**BCA SIGNIFICANT ISSUES & CONSTRAINTS REPORT**  
**PROPOSED GLOBAL SYDNEY SWITCH 2 - REVISED DESIGN**  
**PYRMONT STREET, ULTIMO NSW**

REPORT NO ► 1321-15 REV03

DATE ► DECEMBER 2011

original	scale	drawn	project no.
b1	1:200	dbg	4019-00
drawing no.	rev no.		
<b>ar</b>	<b>1200</b>		<b>B03</b>
Designer	Zone	Number

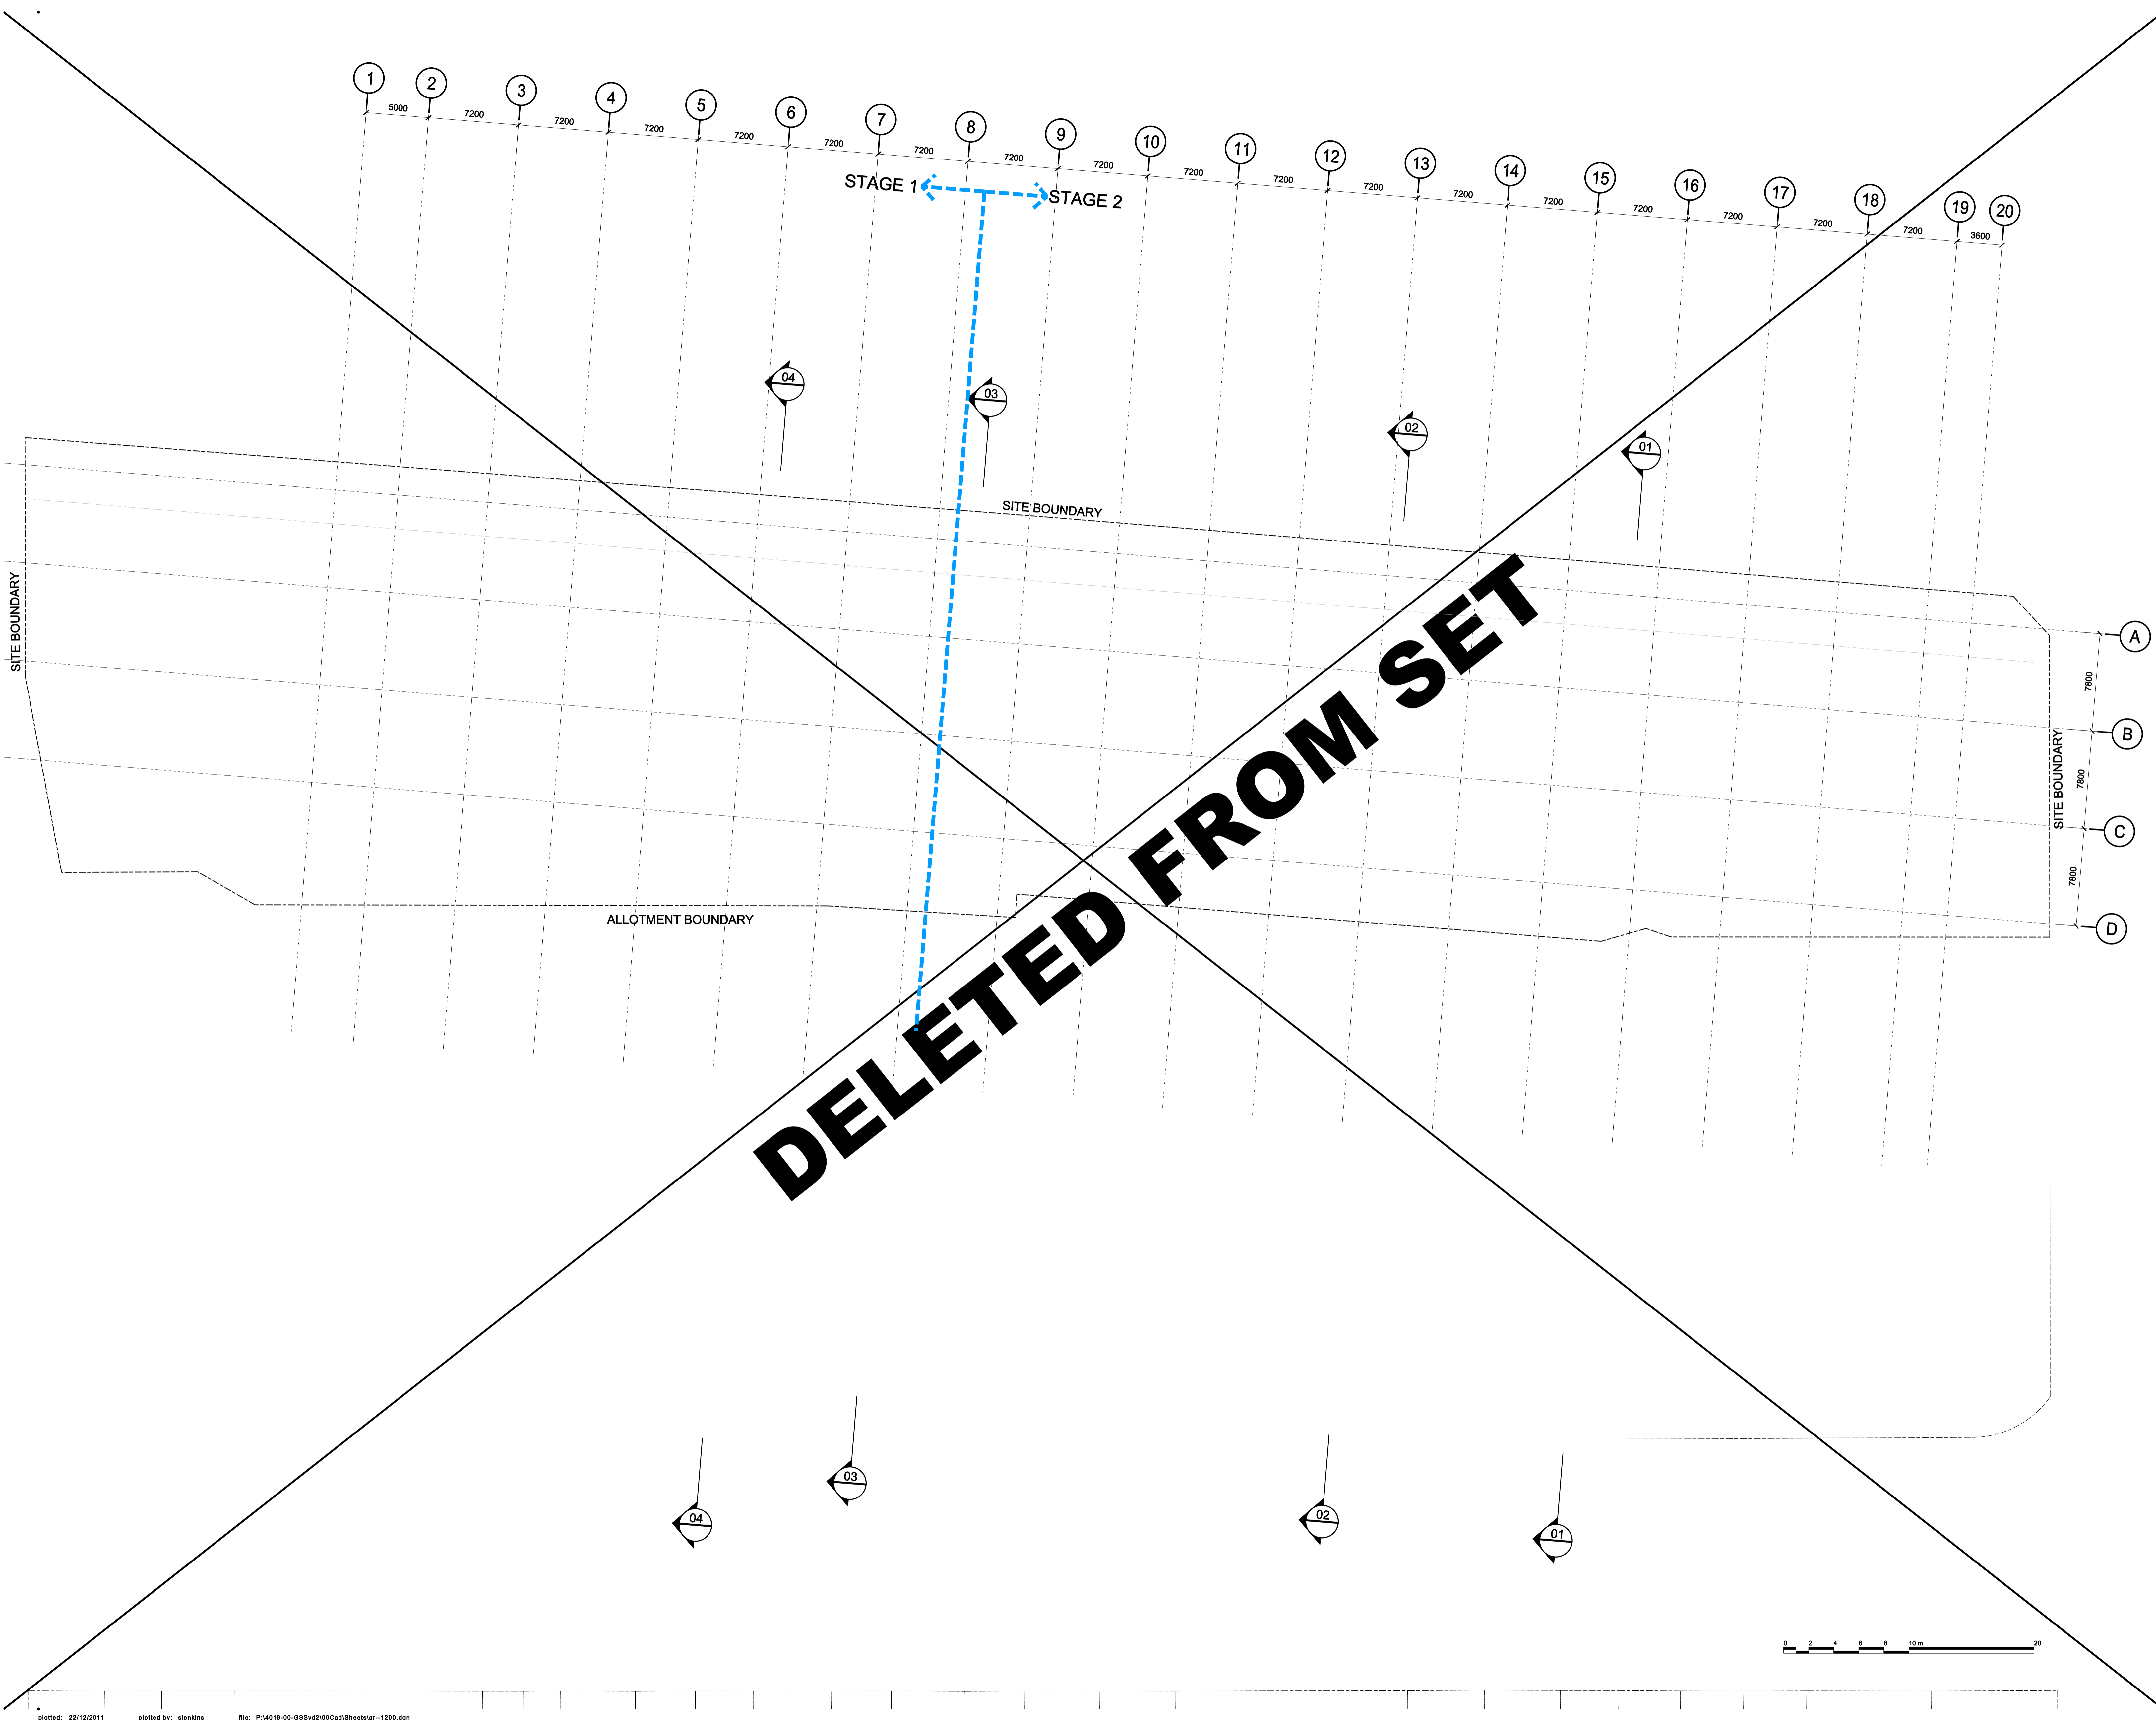
12.	Potential Non-Compliance	<p><b>RISING &amp; DESCENDING STAIRWAYS (BCA CLAUSE D2.4)</b>  The fire isolated stairways that serve the basement (or below ground levels) must not be directly connected to the fire isolated stairways serving the above ground storeys. The stairways must be separated by construction that is non-combustible and smoke proof.</p> <p>This aspect will be further assessed as the design continues to progress.  This relates to the northern most stair at ground level.</p>
